WEST SUSSEX COUNTY COUNCIL CONSULTATION

TO:	Arun District Council FAO: Amber Willard
FROM:	WSCC - Highways Authority
DATE:	31 August 2021
LOCATION:	Land adj to 14 Stoneyfield Cottages, Eastergate Lane, Eastergate, PO20 3SL
SUBJECT:	BN/112/21/PL 1 No. 4 bed detached dwelling and associated parking and gardens. This application is within CIL Zone 3 and is CIL Liable as a new dwelling.
DATE OF SITE VISIT:	N/A
RECOMMENDATION:	Advice
S106 CONTRIBUTION TOTAL:	N/A

Site plan 1:200 @ A3

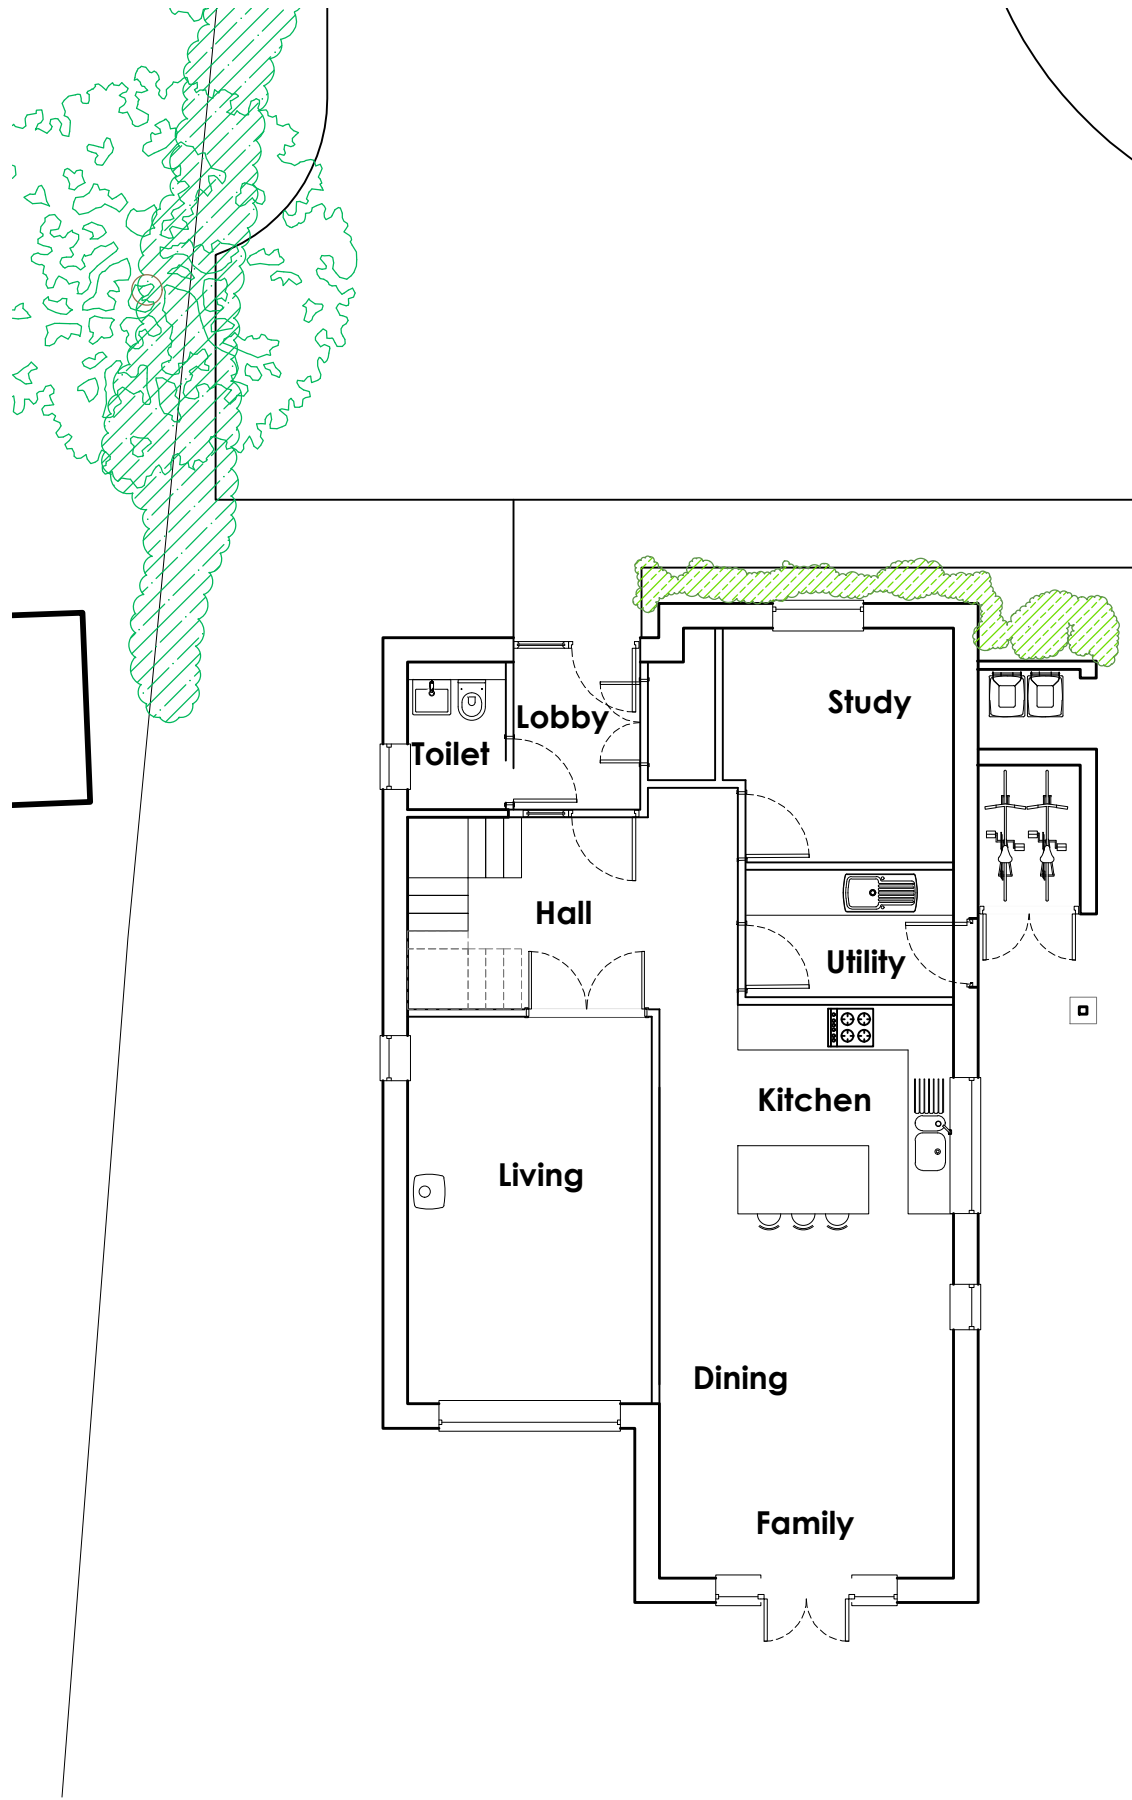
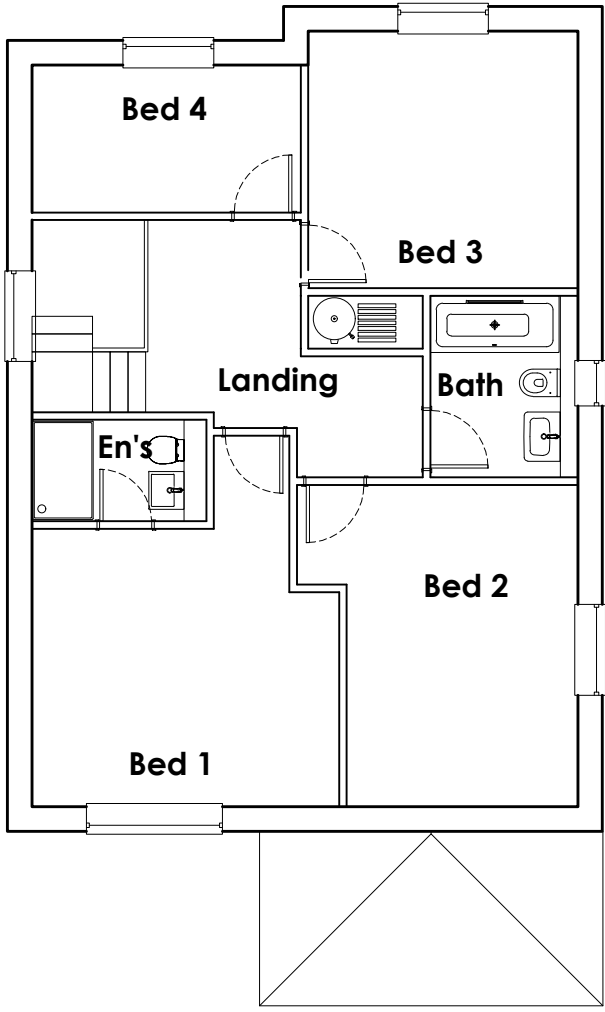
The applicant proposes three car parking spaces for the proposed dwelling. Under Arun Parking Standards, the LHA would expect a parking provision for at least three car parking spaces for a dwelling of this size in this location. Therefore, the LHA considers the proposed parking provision to be sufficient. From inspection of the plans, the proposed parking bays are suitably sized, and the driveway has sufficient space for on-site turning.

Regarding cycles, the applicant has demonstrated a cycle store with provision for two cycles, in accordance with Arun Parking Standards. The inclusion of secure and covered cycle parking provision helps promote the use of sustainable transport methods.

No part of the development shall be first occupied until the car parking has been constructed in accordance with the approved site plan. These spaces shall thereafter be retained at all times for their designated purpose.

No part of the development shall be first occupied until covered and secure cycle parking spaces have been provided in accordance with plans and details to be submitted to and approved by the Local Planning Authority.
